File Name: OES_SEPT4_ISH2_PT5.mp4

FULL TRANSCRIPT (with timecode)

Okay. It's now a 2:15 and it's time for us to resume this issue. Specific hearing. Thank you. So, um, can I just check that the recording and the live streams recommenced? Yep. Thank you very much. So. And again, also just check that those who are online can see and hear as clearly. Super. Thank you. All right. We'll move then on to um the agenda on covering biodiversity and or ecology.

Drawn: JG Designed: SG Approved: SG

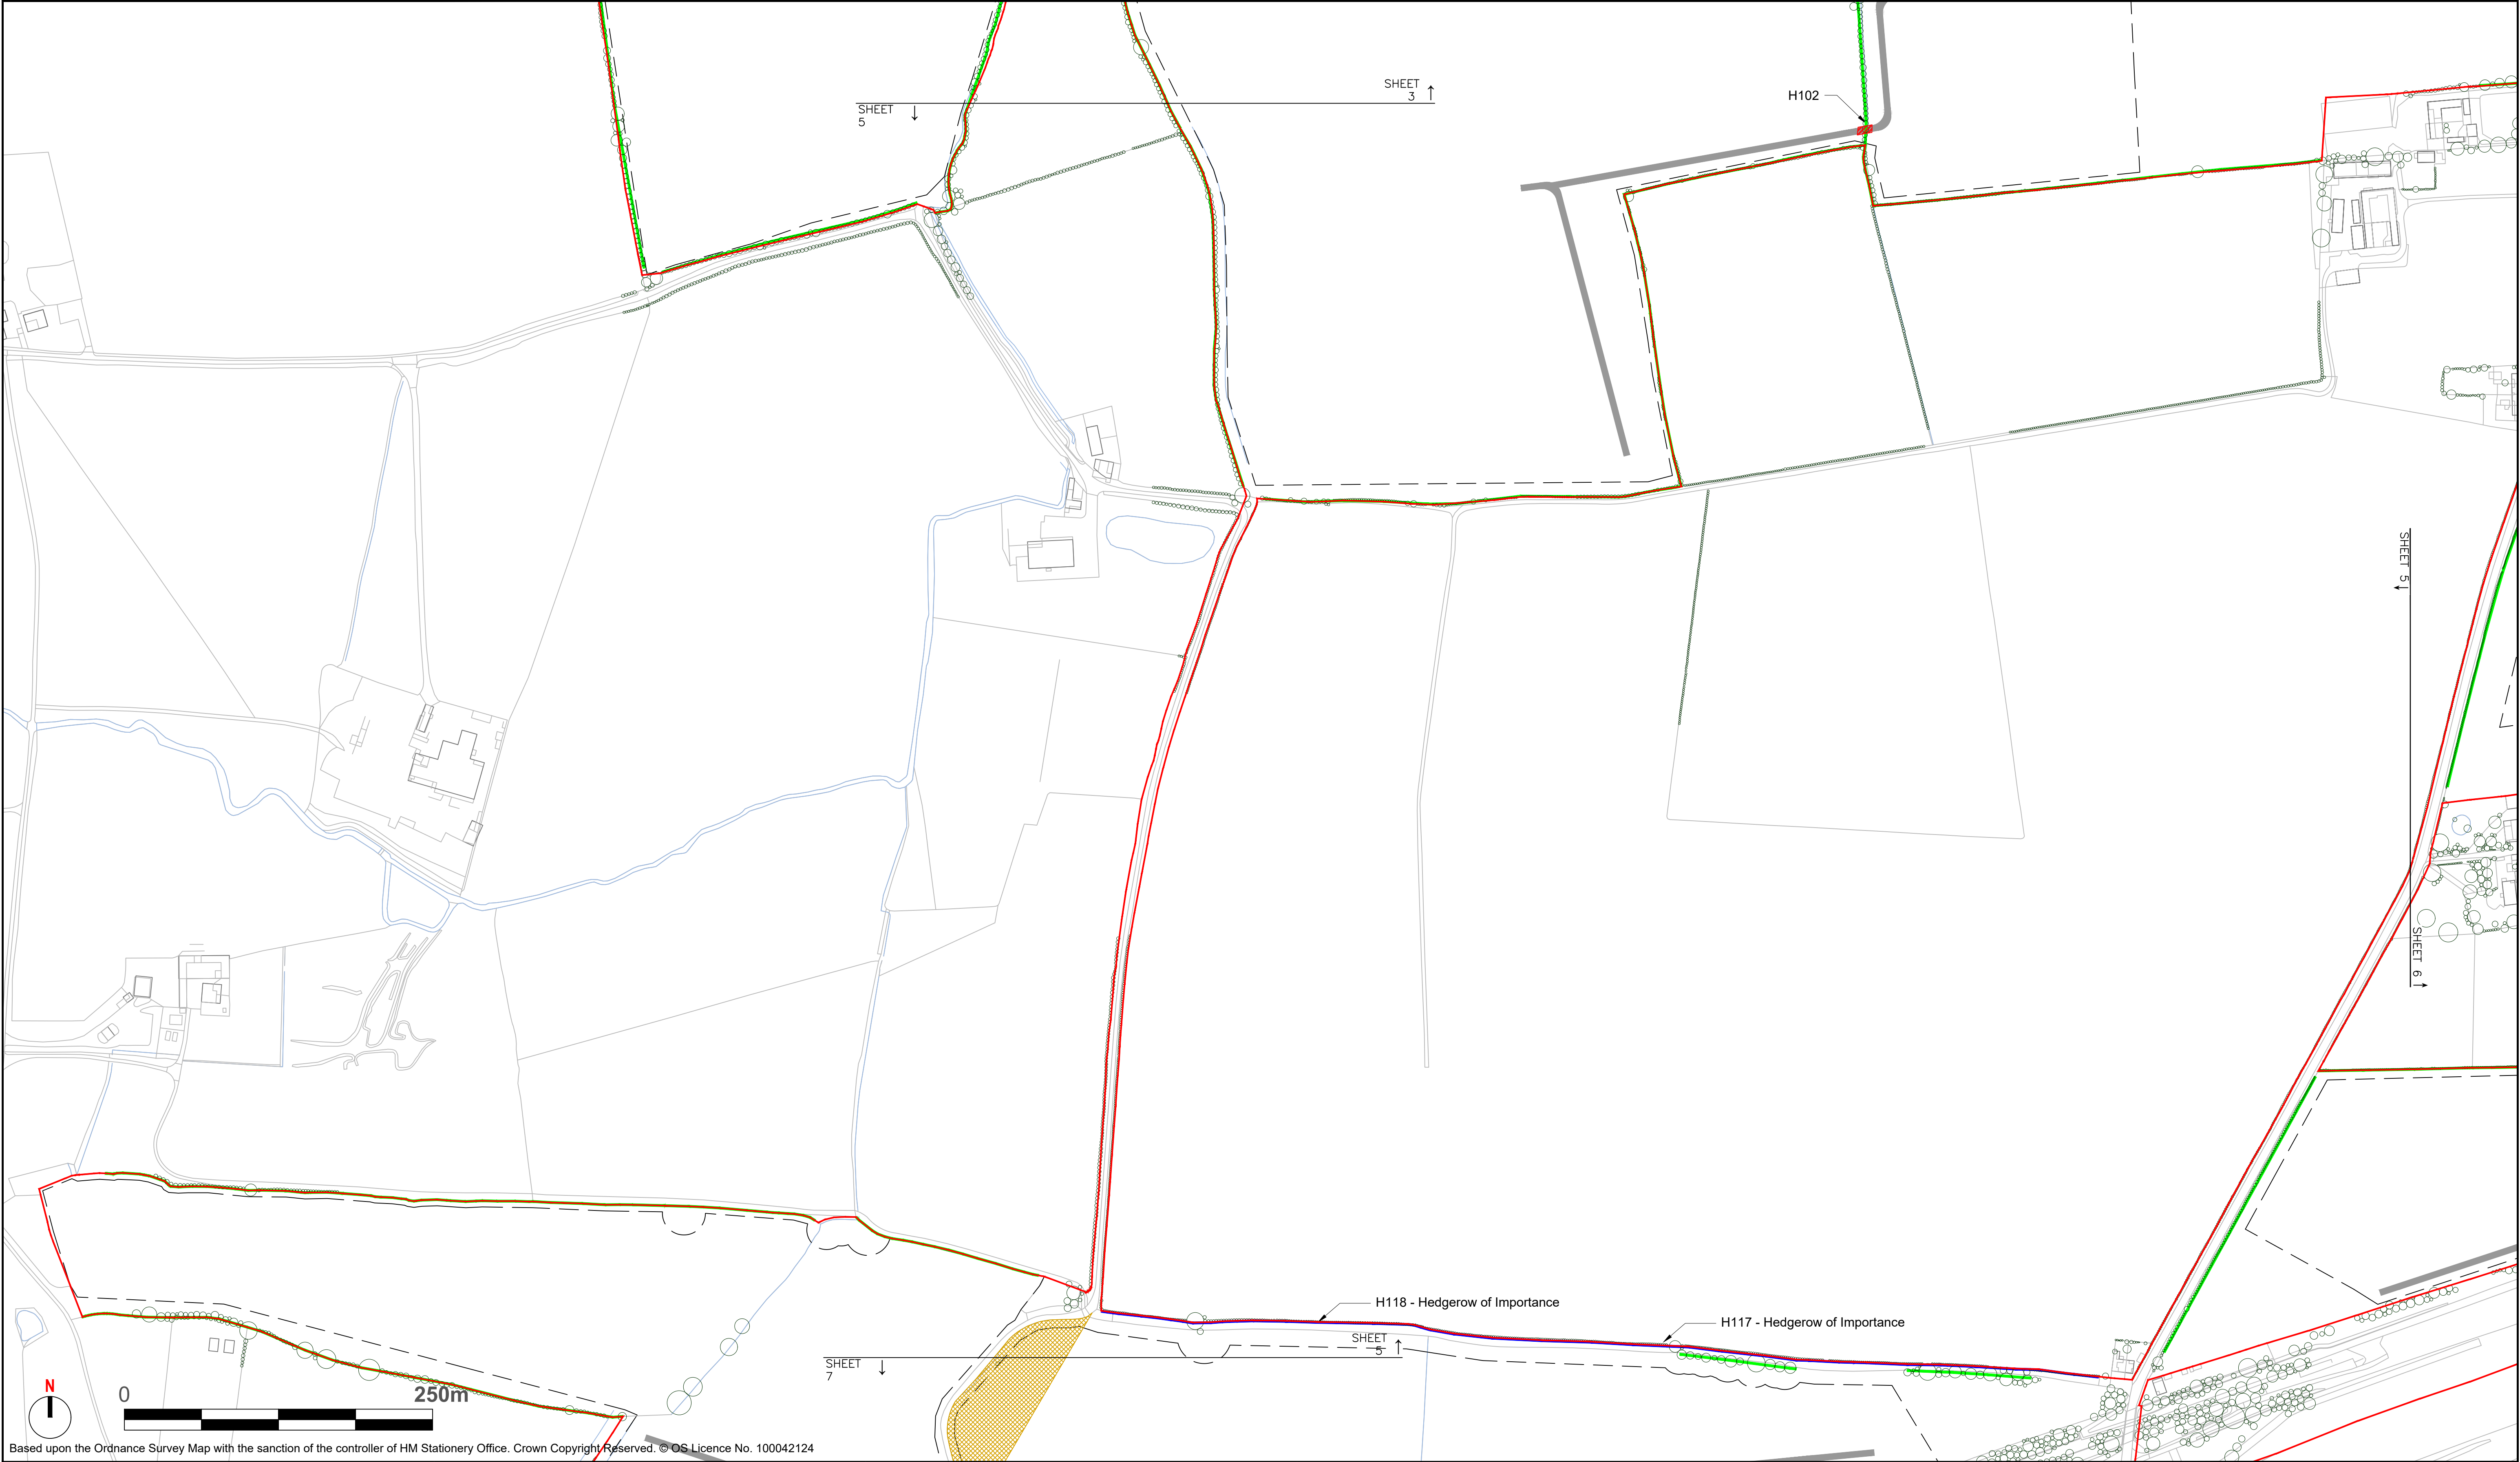
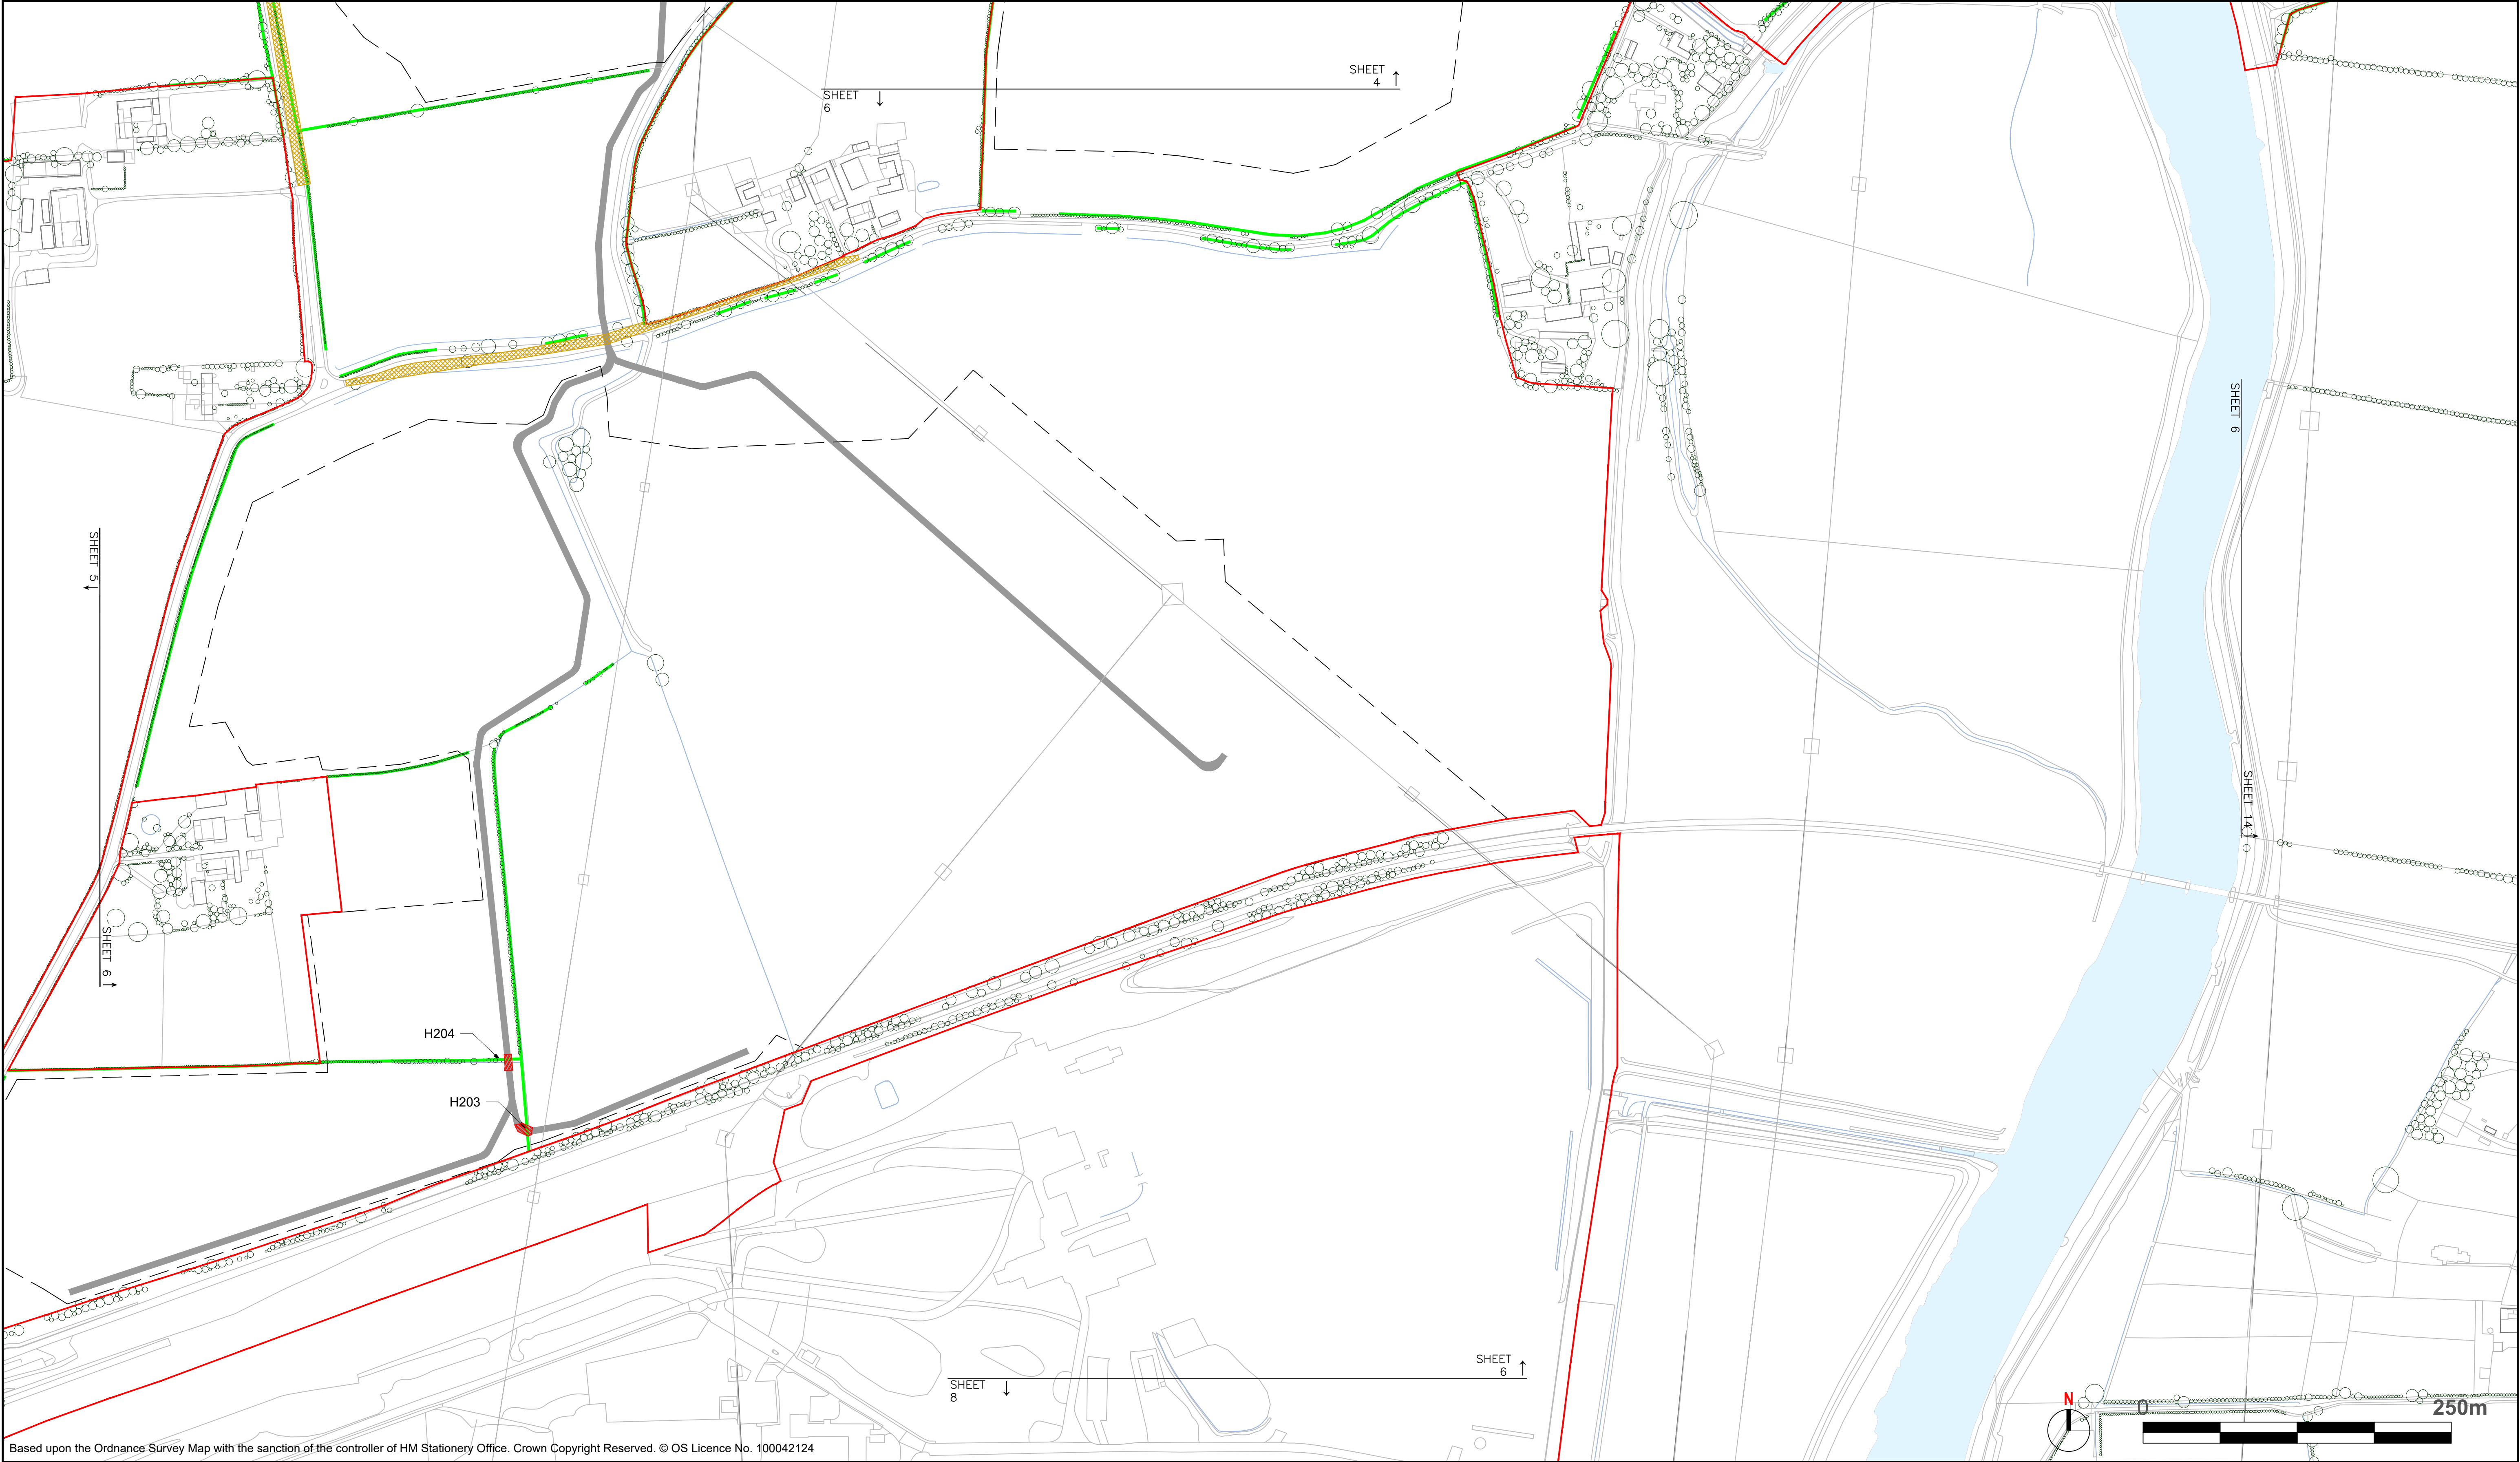
Excuse me. Uh, just really seeking additional clarification from the applicant. How your approach to a animal movement across the site, uh, is to be managed. And what elements of the DCO secure that planet approach? Now we note the response to our written question. 7.0 0.1 um, and you refer us to the appendix C of the vegetation removal plans of the Outline Outline Landscape and Ecology Management Plan, which is Rep 1053.

When you look at each of the sheets in in detail, I think you can see the proposed fence lines. But what it's very difficult to navigate through is where the gaps align, because you can't do it as a whole. So just as a simple request, is it possible to provide in a similar way to the illustrative master plan, a plan showing the route through the site that you anticipate animals are going to be able to follow so that we can see and understand more readily the connectivity across the site as a whole.

Amy Rhodes. Nottinghamshire County Council. My only query would be with the fence locations that there is at the very edges of the fence, to buy any hedgerows to keep that linear connectivity and where animals will pass is that there are gaps in each of the edges and that's it. Thank you.

The very edge of the fetch. So if you've got a fence and it's next to a hedgerow, um, to keep the gaps open next to the hedge, because a lot of animals would use a hedge to get up and down for commuting. So it's just to keep that connectivity across the site by using the hedgerows and then making sure there's gaps in the fences for them to continue that connectivity. That makes sense. Sorry, not very technical.

Allen Kirby, on behalf of the applicant. Um. Simple answer is yes. Um, what we'll try and do is highlight areas within and outside of a fence line. Um, so it's quite

part of the Countryside Stewardship. It has a prescription. Um, the only difference here is on request from one of the local authorities that we don't have the gate. We simply have a framed entrance to allow things to move in and out. So it would just be fitted to the standard wire mesh, um, uh, deer fencing. So the fencing as described in chapter five. And we saw on some of the visualisations yesterday, um, it would be that type of fence, except it would have small gaps around every 150m, as described in the environmental measure.

No, no. That's fine. Um. It's helpful. Thank you. And again, are you able to confirm that? that's the intention. So Alan Kirby, on behalf of the applicant. So the final design would be, um, uh, described in the, uh, the landscape and Ecology Management plan when it's been detailed. Um, at deadline two, the Olymp was updated um, in section seven to describe um working in partnership with local authorities and uh, Natural England and others to have a steering group in terms of informing those things.

So the actual, um, alignment location of those gaps would be discussed and agreed at the time. And so there's no issue with putting those in in places as, as um, Notts County Council were just saying there along hedgerows.
